KITITAS COUNTY

MEMORANDUM

TO: All Staff
FROM: Public Works Plan Review Team
DATE: August 22, 2024- UPDATE 1/26/26
SUBJECT: BL-24-00016 George

**RECORD OF SURVEY  
PART OF SECTIONS 11 & 14,  
TOWNSHIP 18 NORTH, RANGE 17 EAST, W.M.**

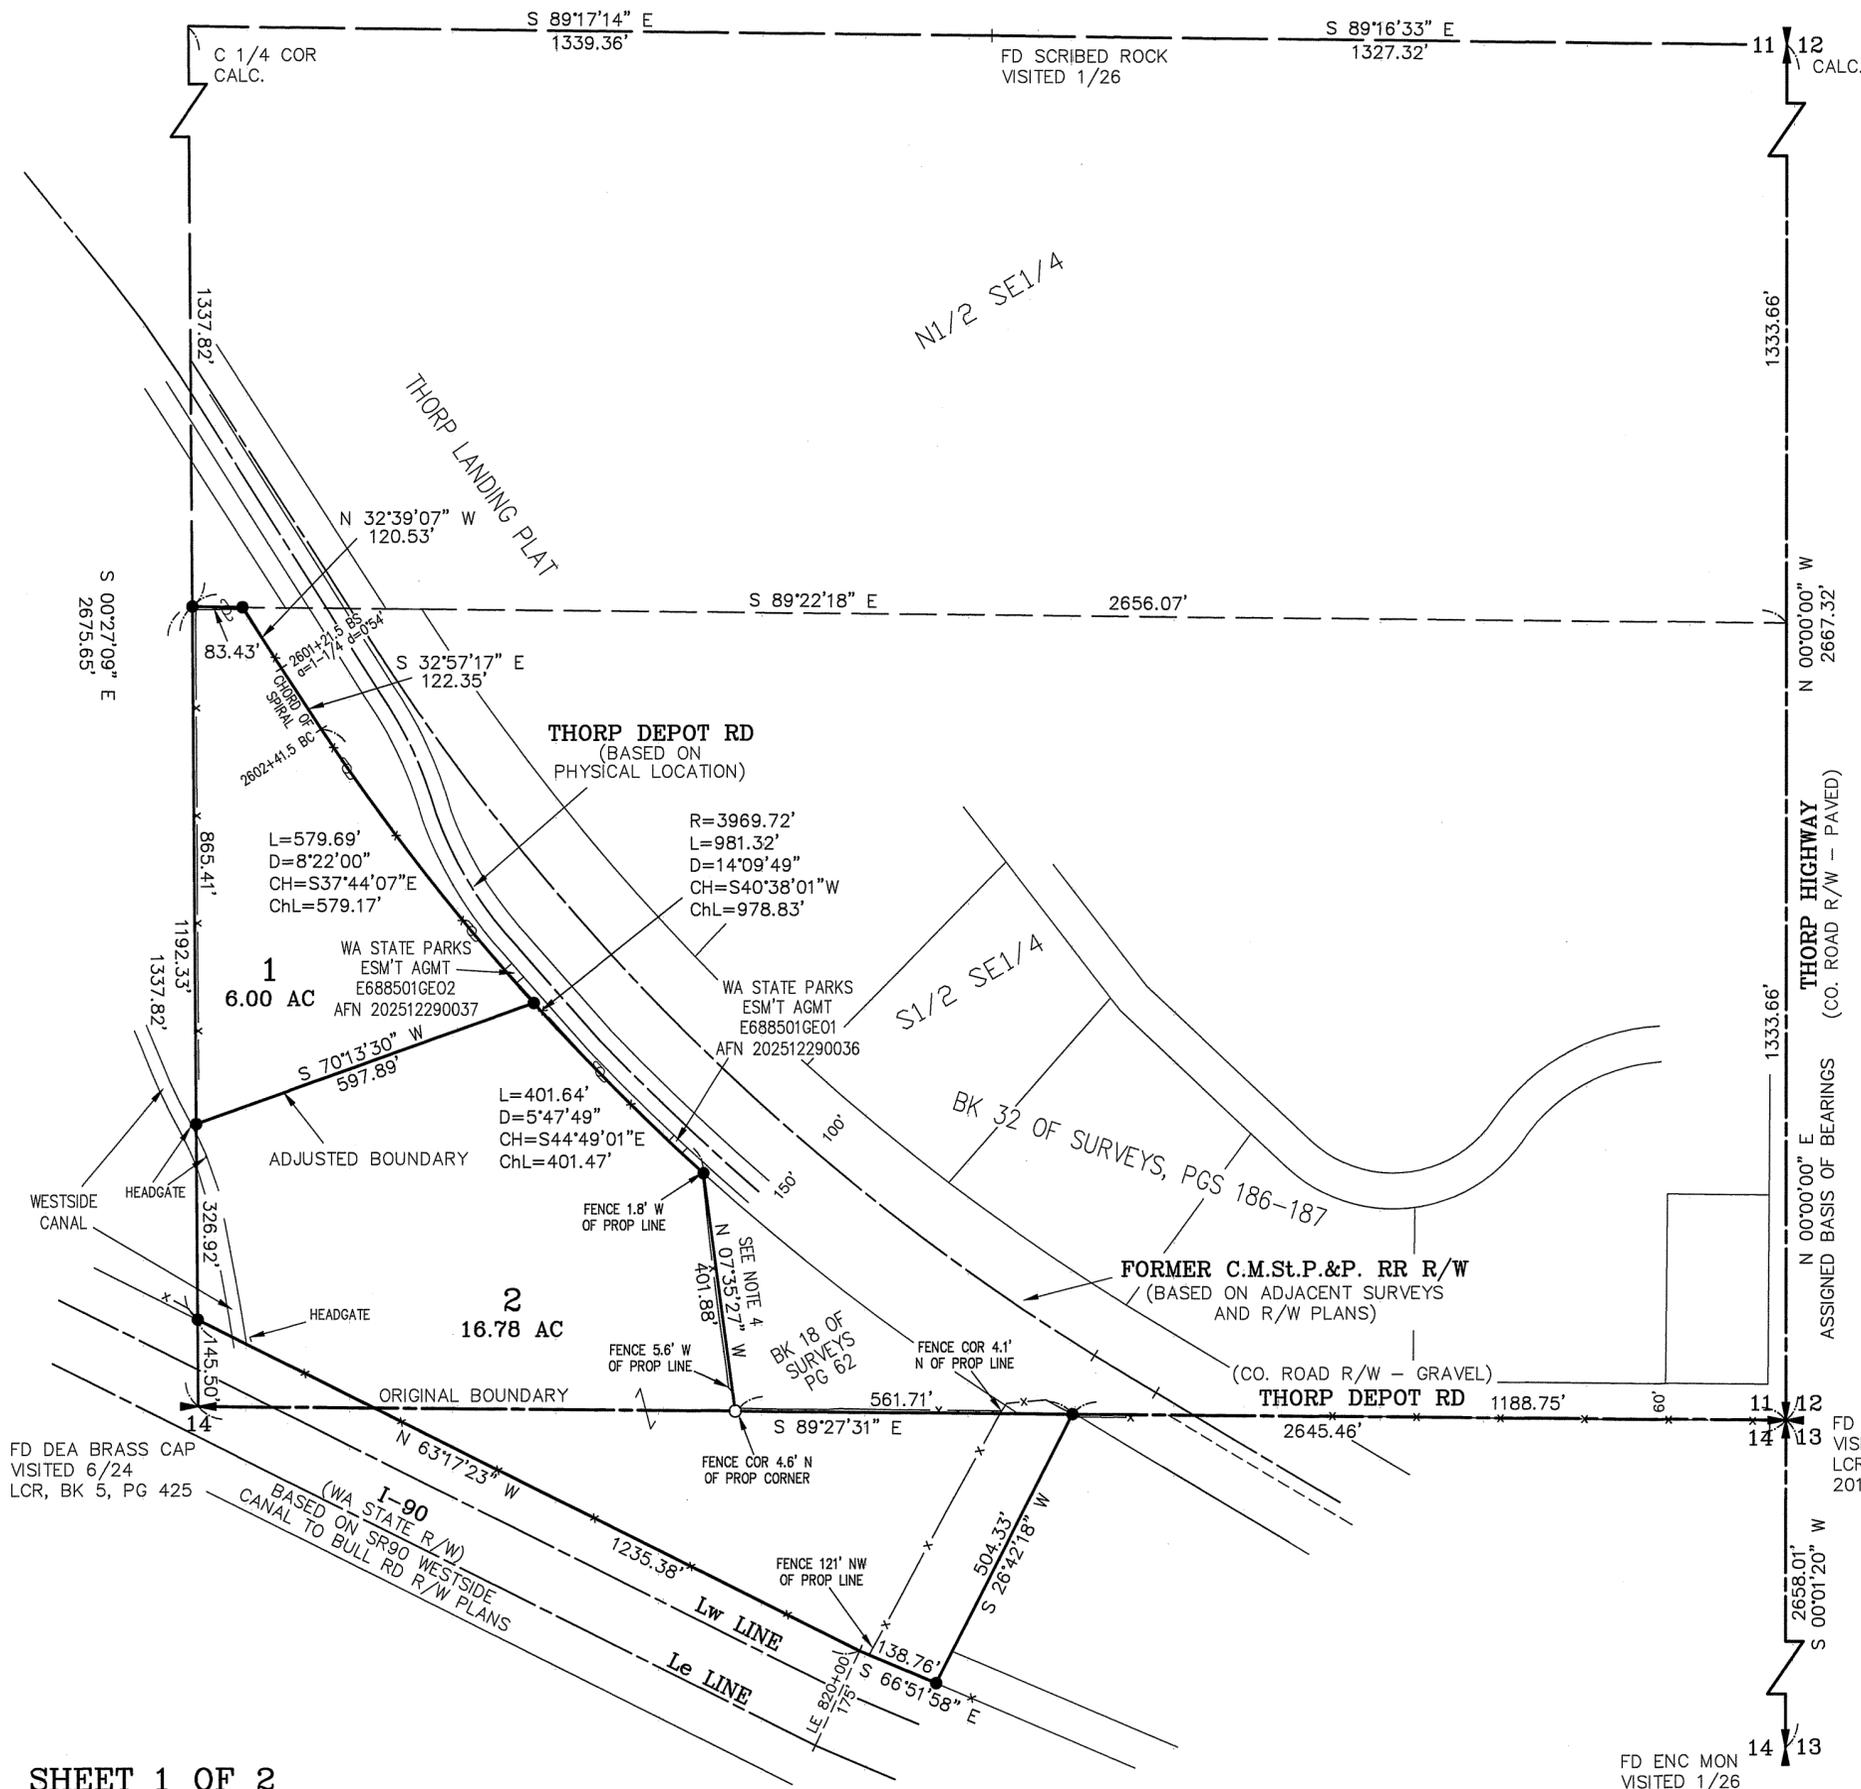
ENGINEERING	<p>Except as exempted in KCC 14.05.060, no grading or filling upon a site involving more than one hundred (100) cubic yards shall be performed without a grading permit from the County Engineer or Public Works designee (KCC 14.05.050). An application for grading in excess of five hundred (500) cubic yards shall be accompanied by an engineered grading plan (KCC 14.05.080). (CP)</p>
SURVEY	<p>As the application does not contain a survey map, comments are herein reserved until final. (JT)</p> <p>UPDATE 01/26/2026 Provided maps were reviewed, and no survey changes are needed.</p> <p>OF NOTE There is a very slight discrepancy between Subdivision Guarantee and the</p>

Existing Legal description. The last line of Parcel 4 "Right of way boundary <u>LINE</u> of the Chicago..." VS "Right of way boundary of the Chicago..." No changes required. (JT)
TRANSPORTATION CONCURRENCY	No transportation concurrency requirement for this project. (KAH)
FLOOD	No comments. (SC)
WATER MITIGATION/ METERING	No comments. (SC)
AIRPORT	No comments. (JS)
